Recommendation Report for Planning Permission

REF NO: M/124/17/PL

LOCATION: 74 Elmer Road
Middleton on Sea
PO22 6EX

PROPOSAL: Retention of salon, erection of first floor extension & single storey rear extension to create a 1 bedroom apartment (resubmission following M/86/17/PL).

Drawn By L.O. Dwg. No. 010817 / SL-30 A

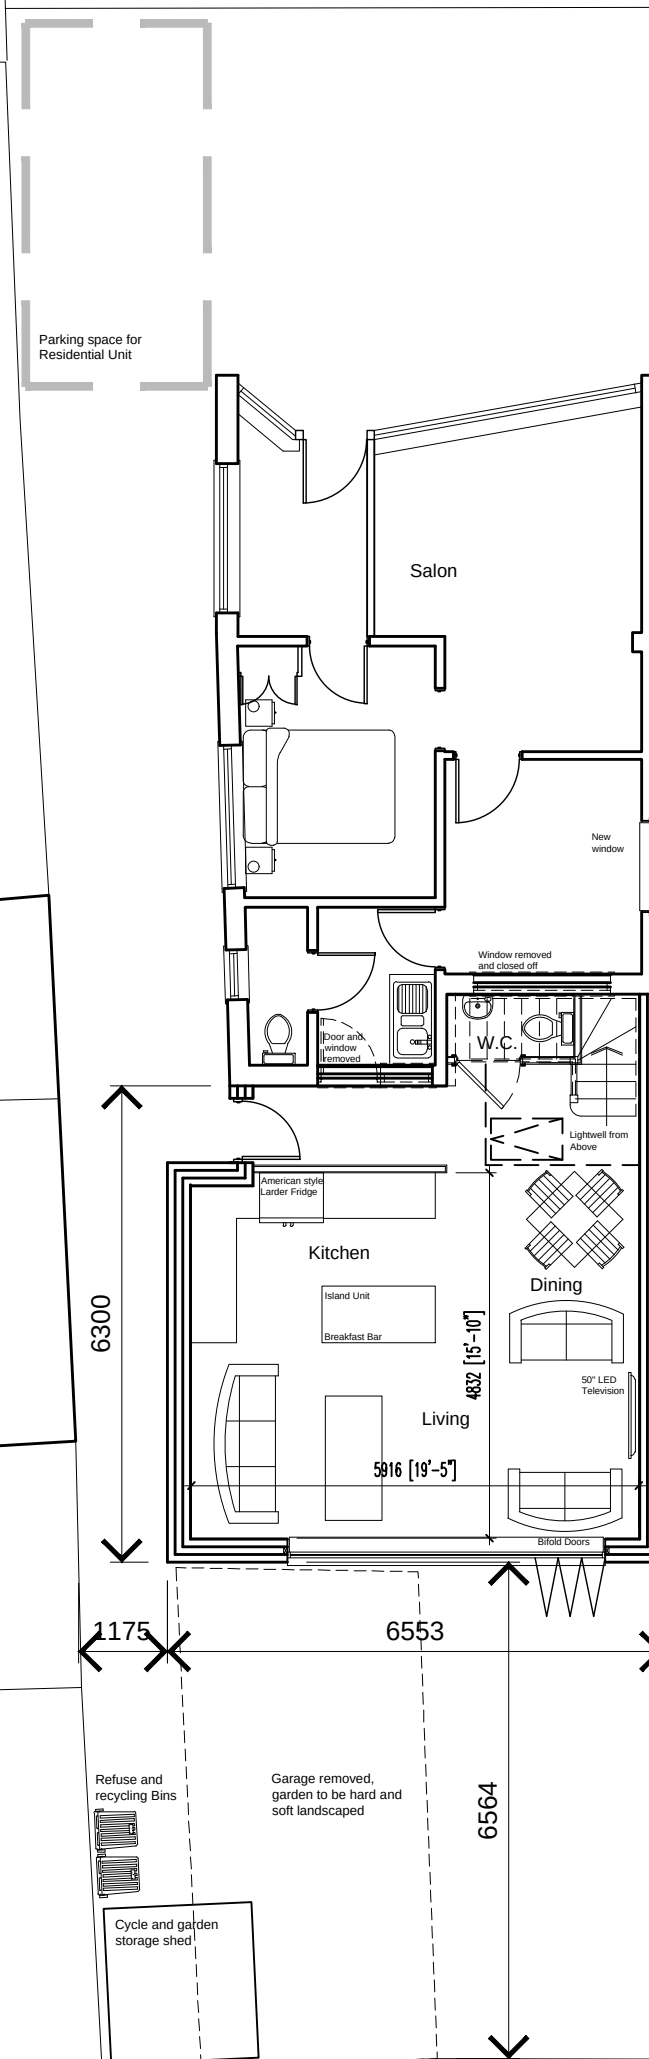
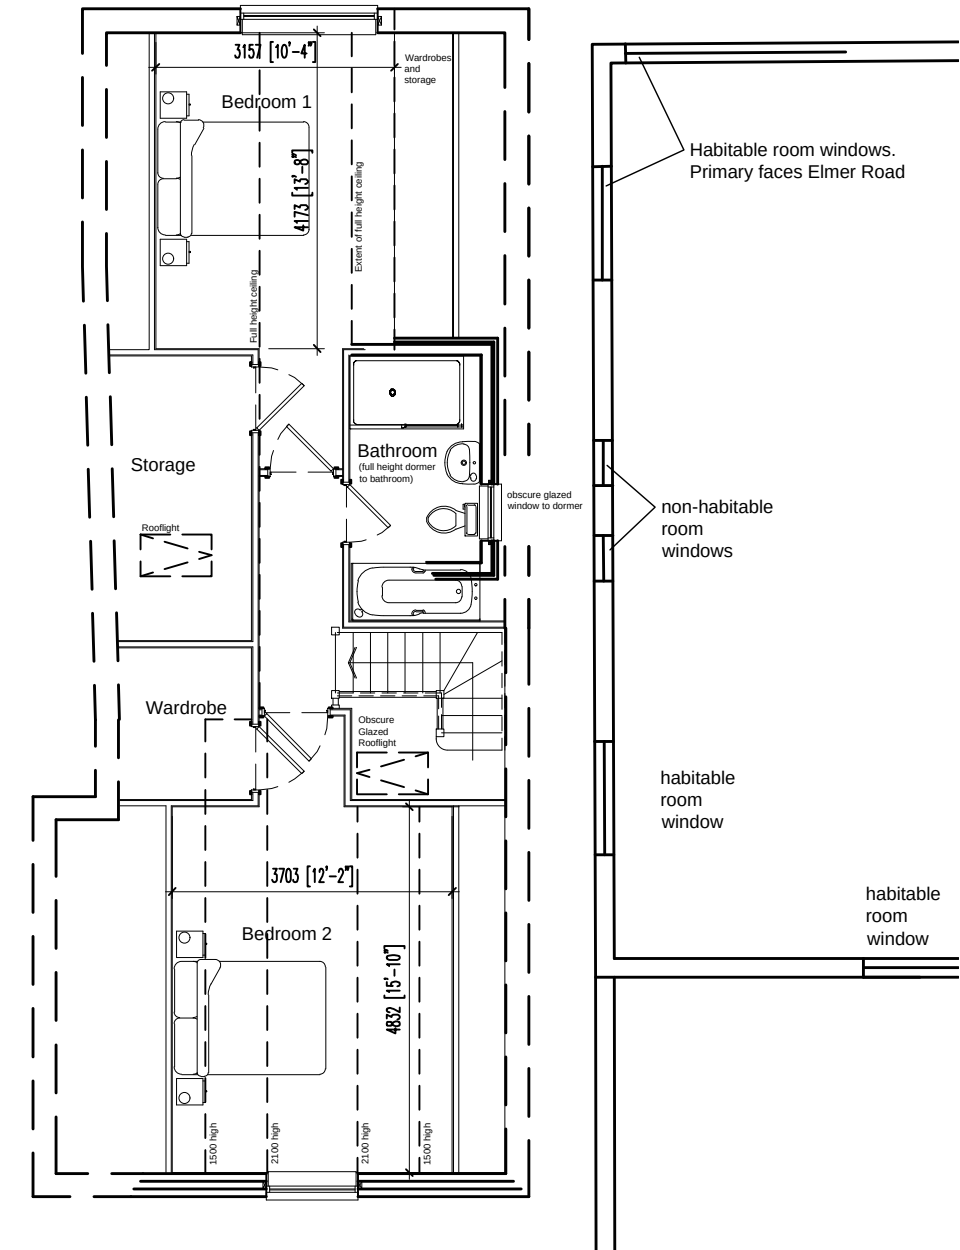
New developments are required to meet the room size guidelines. The minimum Essential General Internal floor area for a 1 bedroom 2 person 2 storey dwelling is 58 sq m. The proposed dwelling has a minimum internal floor area of 58 sq m. The bedroom floor area at first floor with limited headroom cannot be included in the calculation. The property meets this requirement.

The layout includes a parking space on the site frontage for the residential unit and includes a shed in the rear garden for cycle parking. The reduced car parking provision and the reversing of vehicles onto Elmer Road are considered acceptable by County Highways. It would be difficult to substantiate that any

Drawn By L.O. Dwg. No. 010817 / SL-31 D

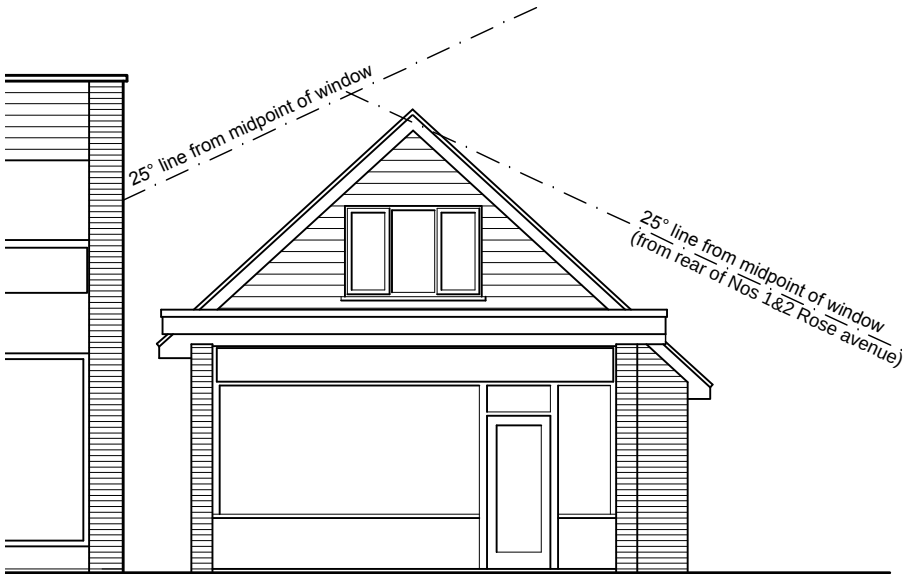
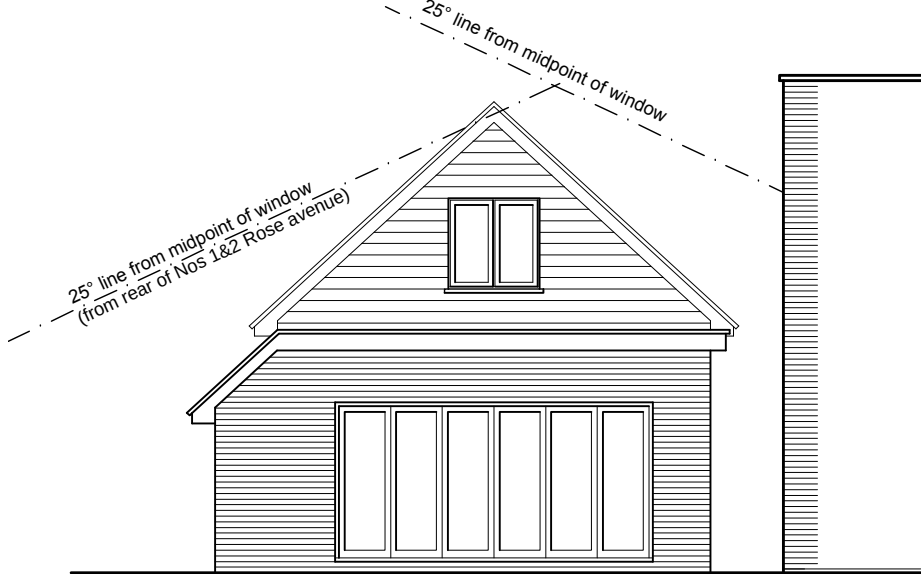
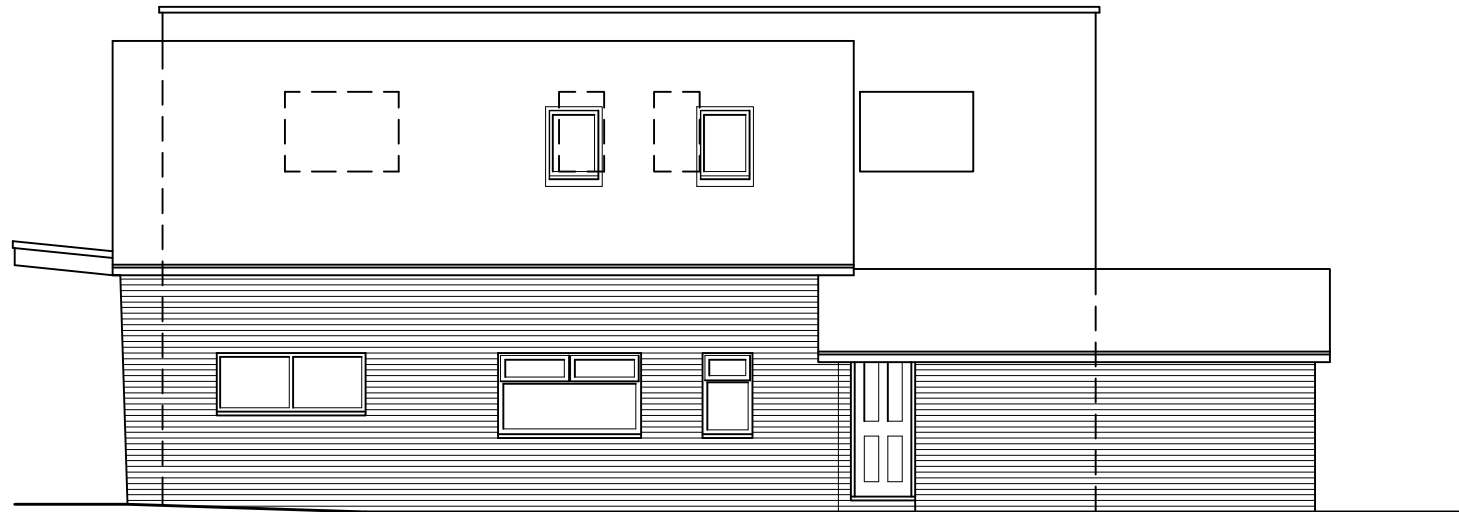
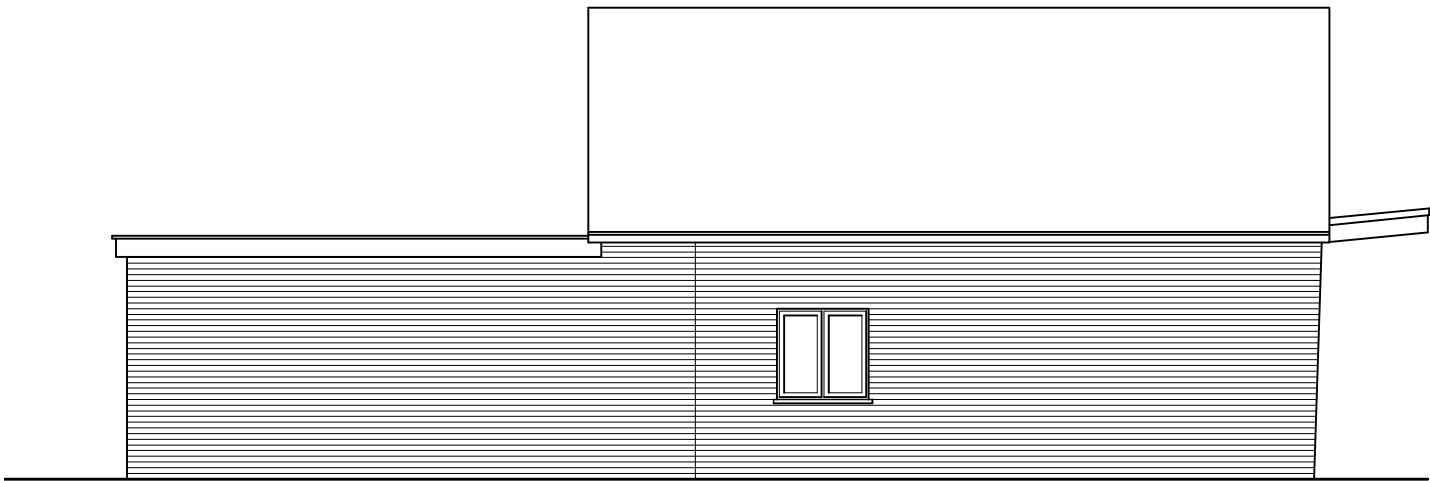
The proposal would extend beyond the rear of the existing premises and would create a first floor that is directly in front of the adjoining 2 storey premises to the east which has 2 windows serving non habitable accommodation and a secondary first floor window facing onto the application site. The building is located on the boundary and the roof pitches away from the boundary. Given the length and height of the extension and the nature of the adjacent windows the loss of outlook to this property would not result in material harm.

Further since the first floor rear portion of the extension which was close to the very limited garden areas serving 1 and 2 Rose Avenue which have a depth of 4m has been removed it is considered that there would now be no materially adverse overbearing effects on these properties and their garden areas in compliance with policy GEN 7 (iv). The eaves would not project significantly above boundary fencing and the roof would pitch away above.

The dormer window in the east side elevation has been removed from the application and there are no windows proposed in the west elevation. The window in the rear which would be 6.5m from the boundary would look onto an area used for parking in Shaw Close. This means that no material loss of privacy would result to neighbouring dwellings.

It was considered that this application as originally submitted did not address this reason for refusal. Following negotiation the application has been amended since originally submitted by reducing the length of the first floor extension to a point that is now considered to be acceptable in terms of impact on residential amenity.
